## MP 08\_0241 MOD 4 – Response to Submissions

We write in response to submissions received in regards to the MOD 4 application for Major Project 08\_0241 at 100 Mount Street, North Sydney. We've reviewed the submissions received by North Sydney Council (Council) and Transport for New South Wales (TfNSW) and provide responses for each below.

drawing
Plan - B5 Level

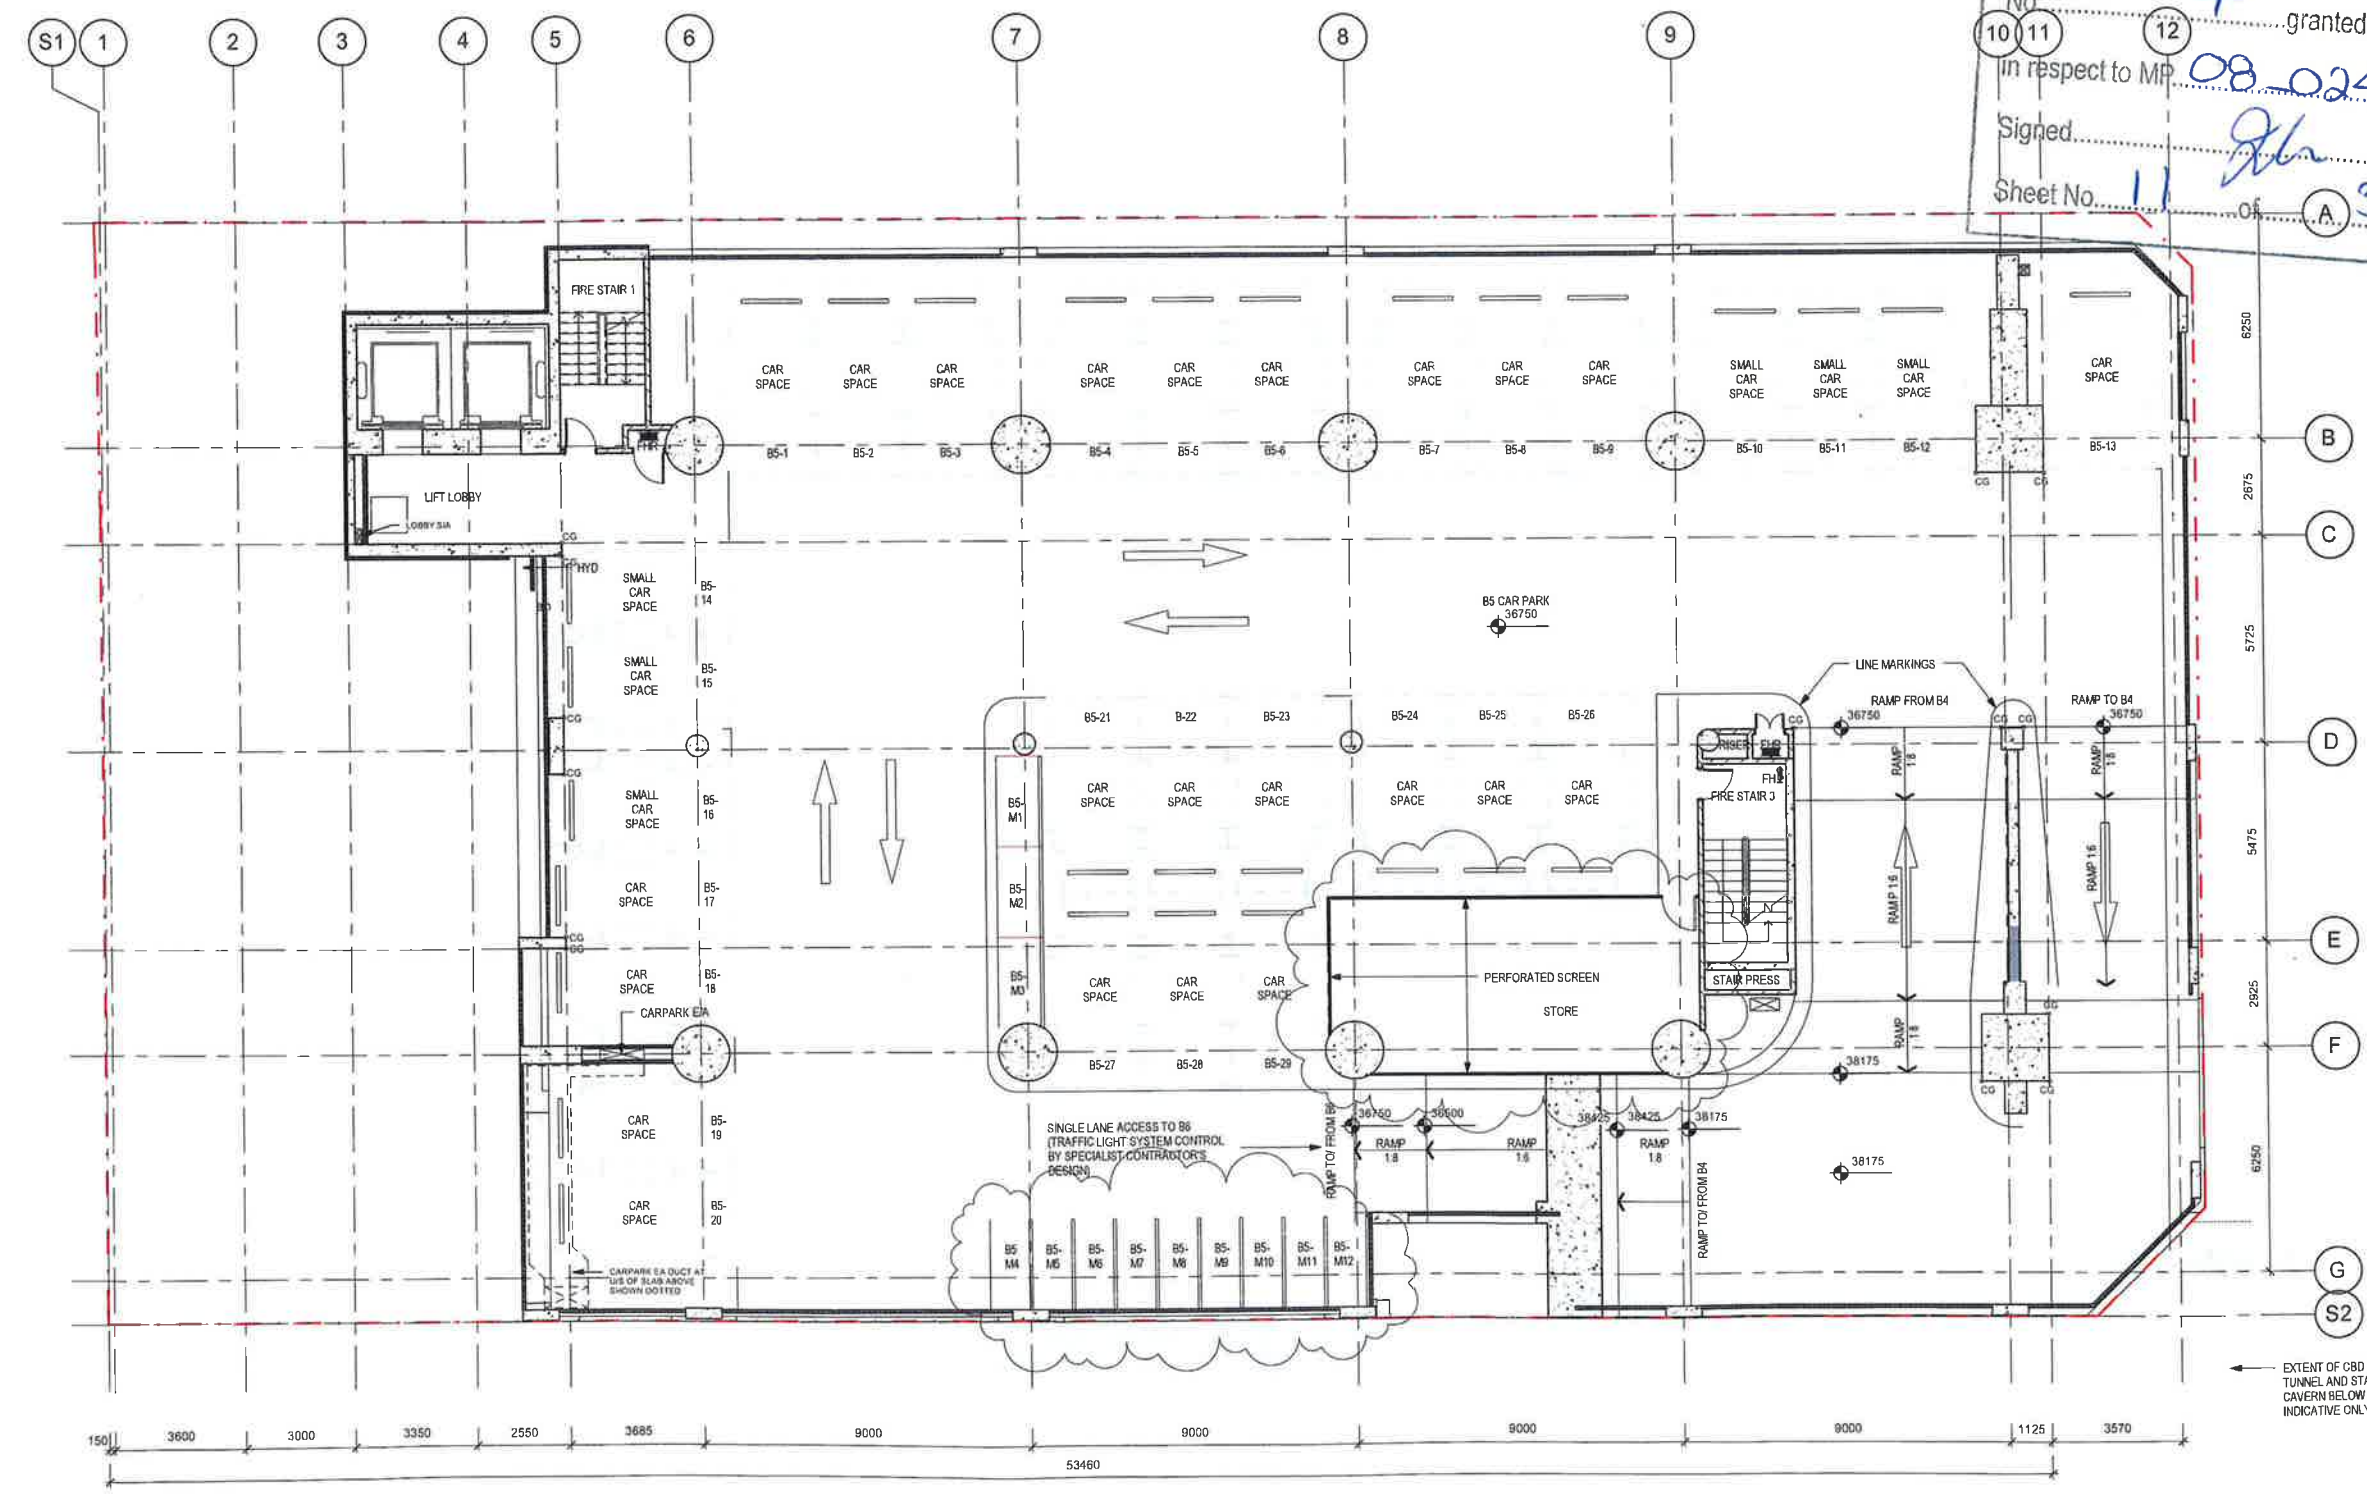
The second query relates to the single width ramp along the southern portion of the site which connects the B5 and B6 Levels. TfNSW have asked what the levels of the ramp are to ensure that they are in accordance with the Project Deed.

As a result of the increase in the RL of the B6 Level, the landing of the ramp between the B5 and B6 Levels has also been raised by 125mm from RL 35.25 to RL 25.375. The RL of the B5 Level has not changed from RL 36.75 in accordance with the Project Deed.

The B5 and B6 Level plans (DA123) have been updated to show the bicycle parking and B5 to B6 ramp levels, and have been attached, along with a copy of the Project Deed, as appendices to this letter.

drawing Plan - B6 Level

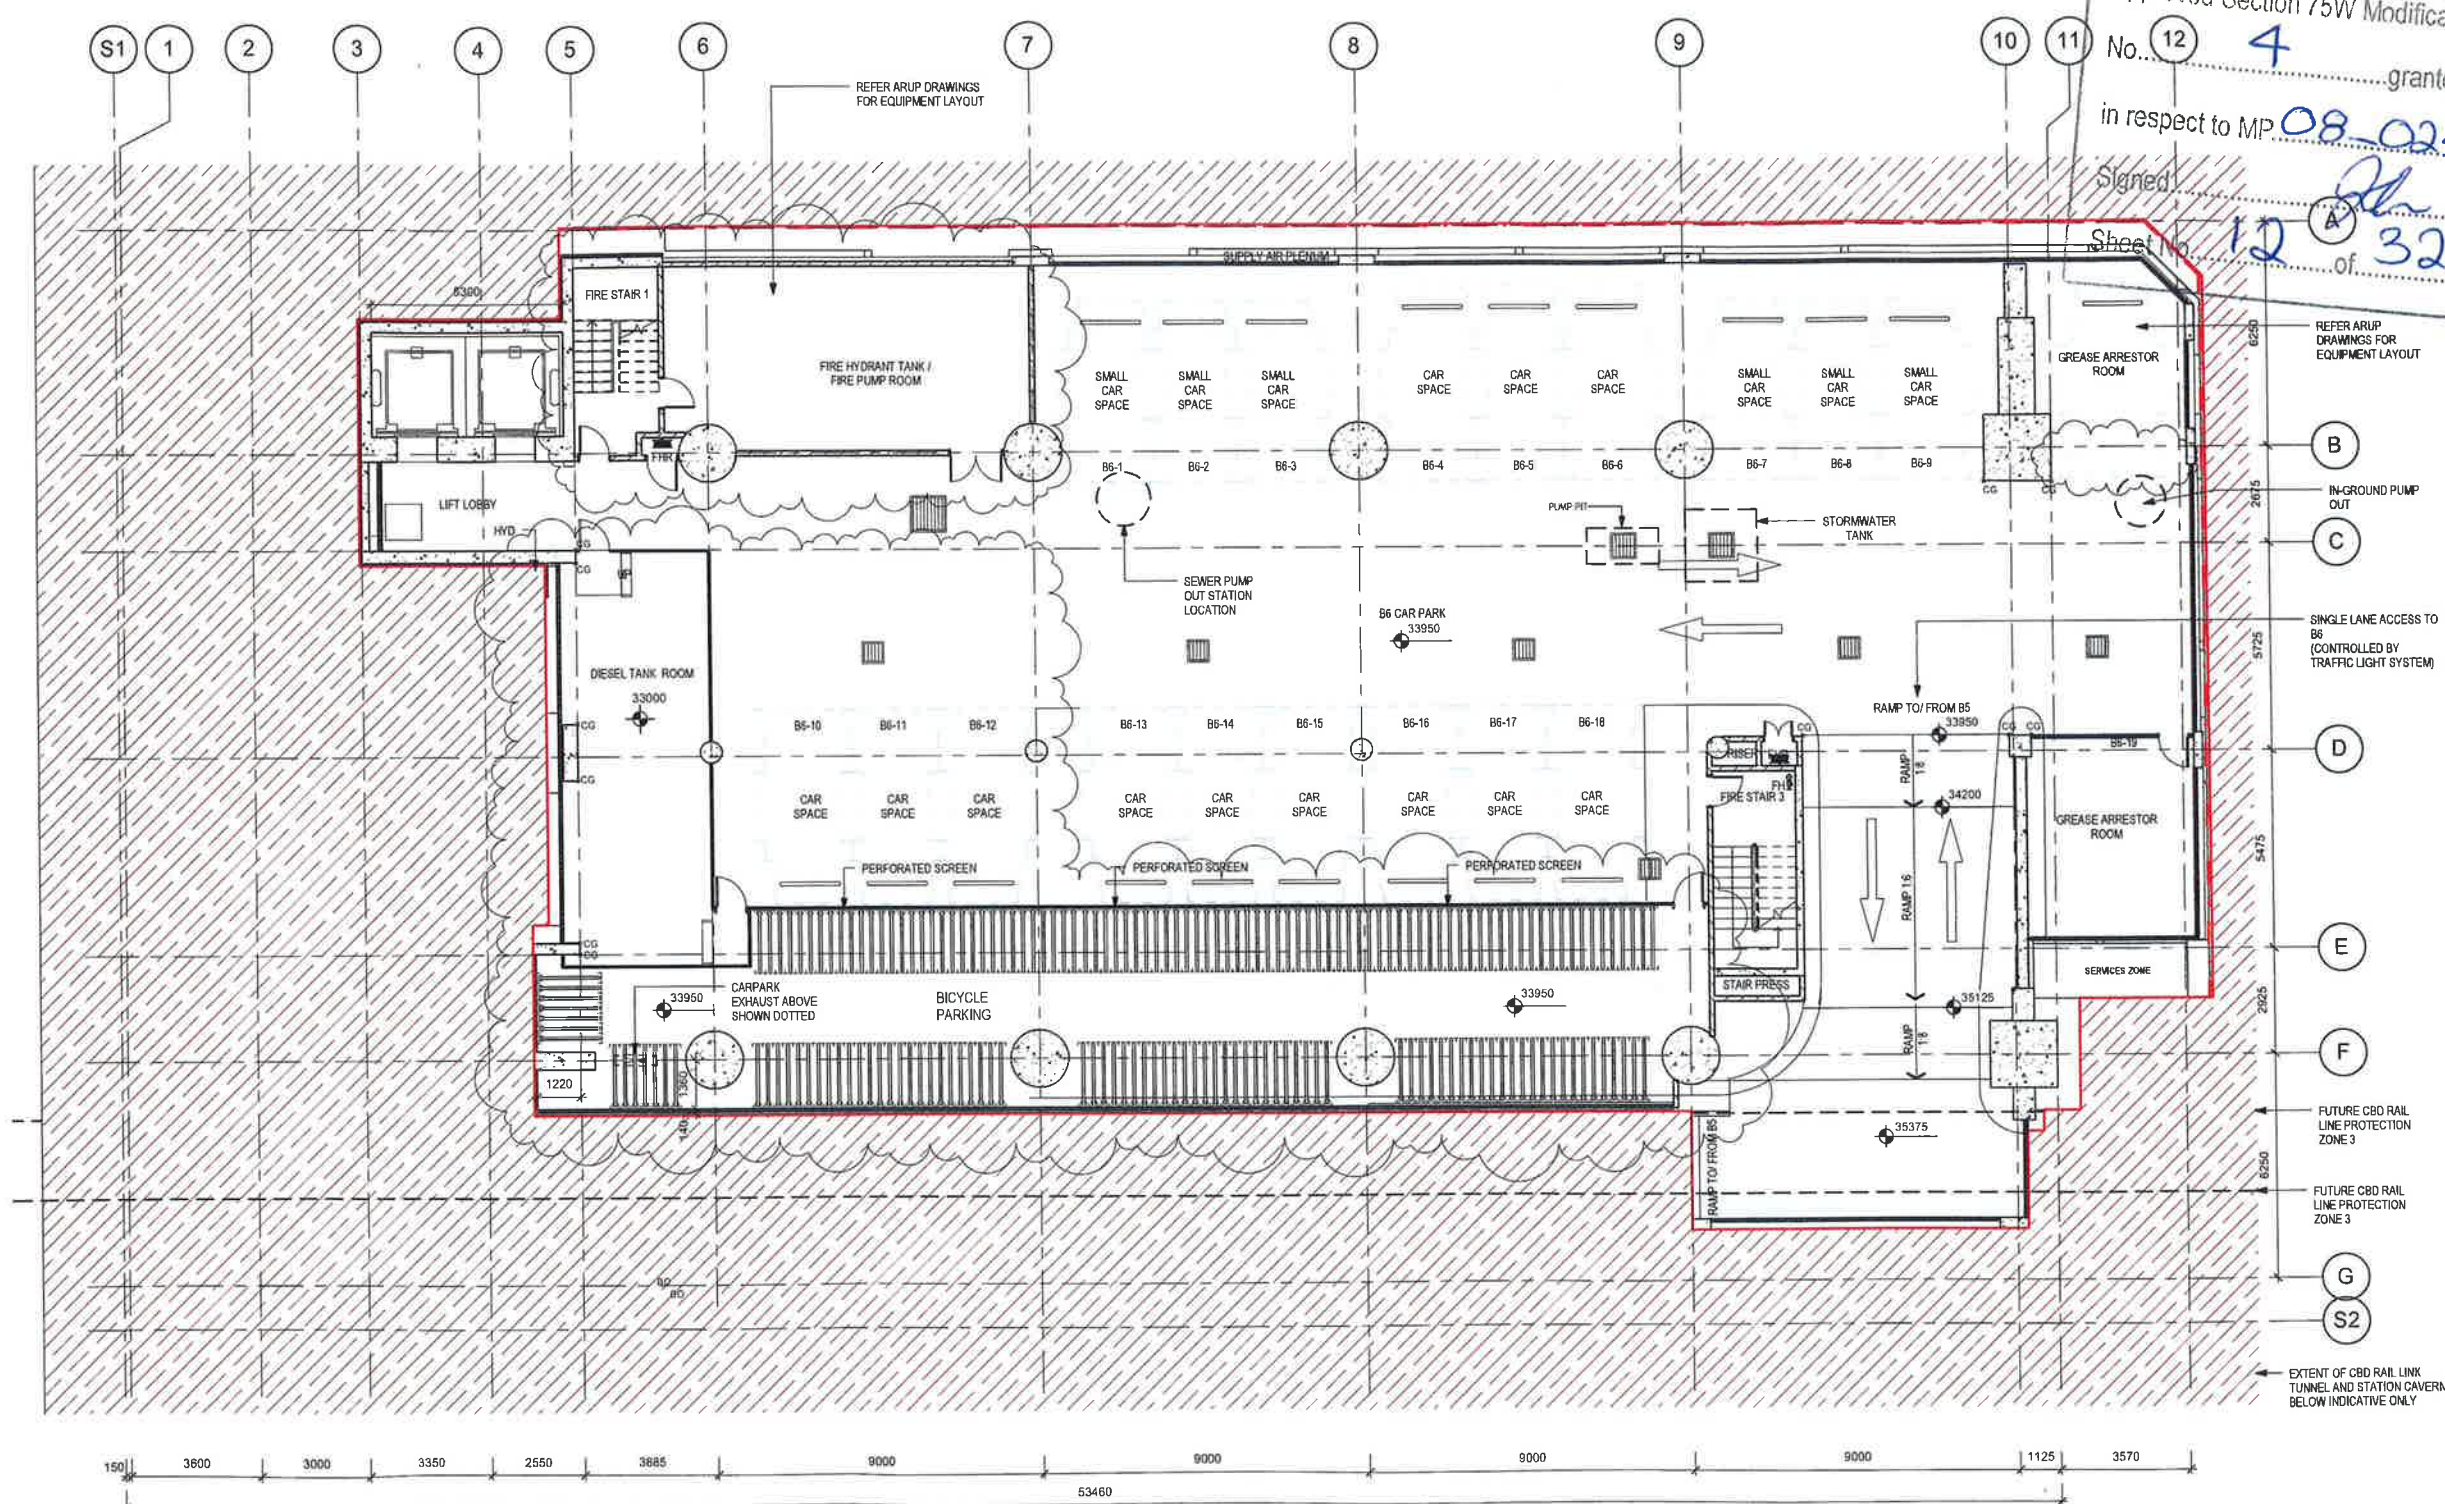
The first query relates to the proposed bicycle parking area on level B6, and that the plans submitted with the application did not show the RL of this area. The level of the bicycle parking area will be RL 33.95, which is 200mm higher than the approved level. Accordingly, there will be less encroachment into the structure exclusion zones.
